Reference No:	2026/62/91349/W
Site Address:	23, High Street, Scapegoat Hill, Huddersfield, HD7 4NJ
Description:	Alterations to convert offices to 2 flats
Recommending Officer:	Joshua Merriman

DECISION – Full Conditional Permission

Officer Report – 2026/91349

Dwg ref: 23HS/P02 : Scale 1:100 @ A3 : May 2026

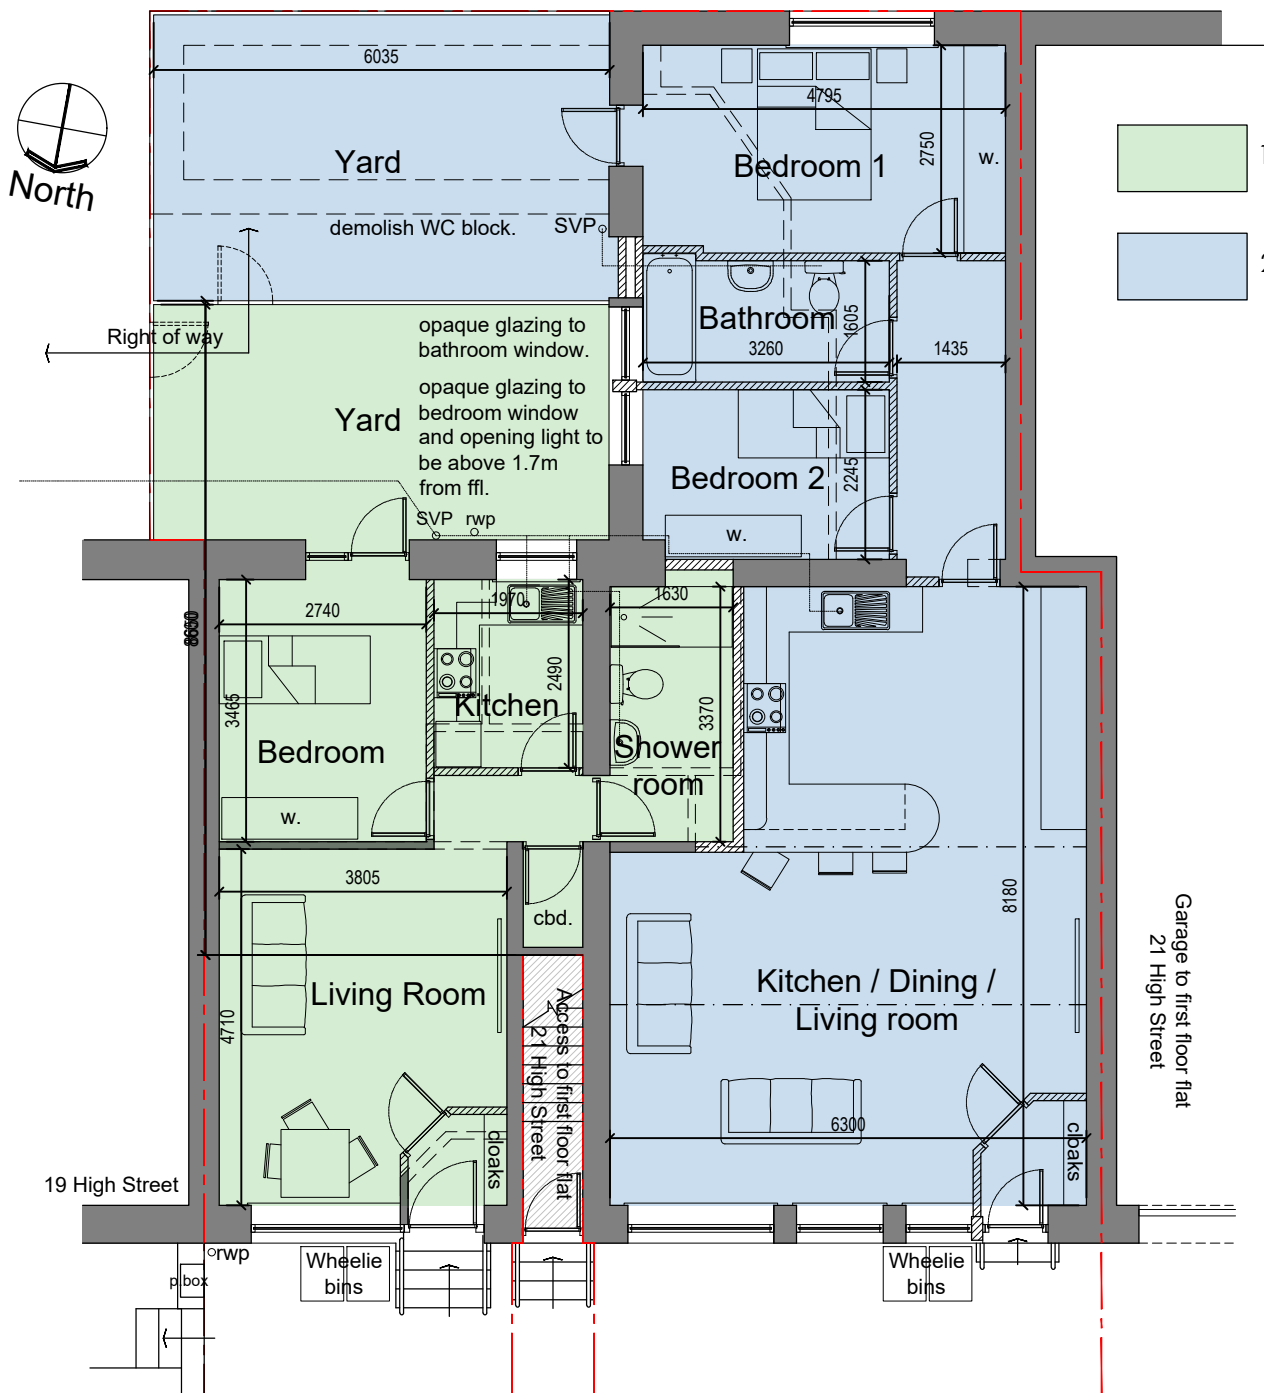
With regard to Principle 16 of the Housebuilders SPD and the technical housing standards of the NDSS which outline that 2-bedroom flats for 3 persons (Flat 2) requires a total floorspace of 70m², and a 1-bedroom flat for 1 person (Flat 1) requires a total floorspace of 39m². This is not considered an issue for either flat, as the total floor space of the properties would be 78m² and 42m², respectively.

Furthermore, with regard to amenity space for both flats, due to their limited scale it is considered that the small area of amenity space assigned to each flat in the rear courtyard is an acceptable amount, furthermore, as they are only designed for a maximum of one and three occupants it is deemed that the amenity space provided will be adequate for this number of residents.

All living rooms, bedrooms, and kitchens are considered to receive an adequate amount of light and are serviced by acceptable openings to ensure a good standard of amenity for users. Furthermore, the use of opaque glazing to the bathroom and single bedroom in Flat 2 means there will be no overlooking into the rear yard space assigned to Flat 1.

Bin storage is shown within the 2m curtilage in advance of the building line which is acceptable from the highway perspective since this area falls outside of the extent of the public road, assuming clearance of any retained or new meters and the post box. Yet, there could be negative impact on the streetscene.

2. The proposed '1 bed/1 person' flat annotated upon submitted drawing '23HS/P02' shall have no more than one bedroom with space for one persons and the proposed '2 bed/3 person' flat upon the aforementioned drawing shall have no more than two bedrooms with space for 3 persons.
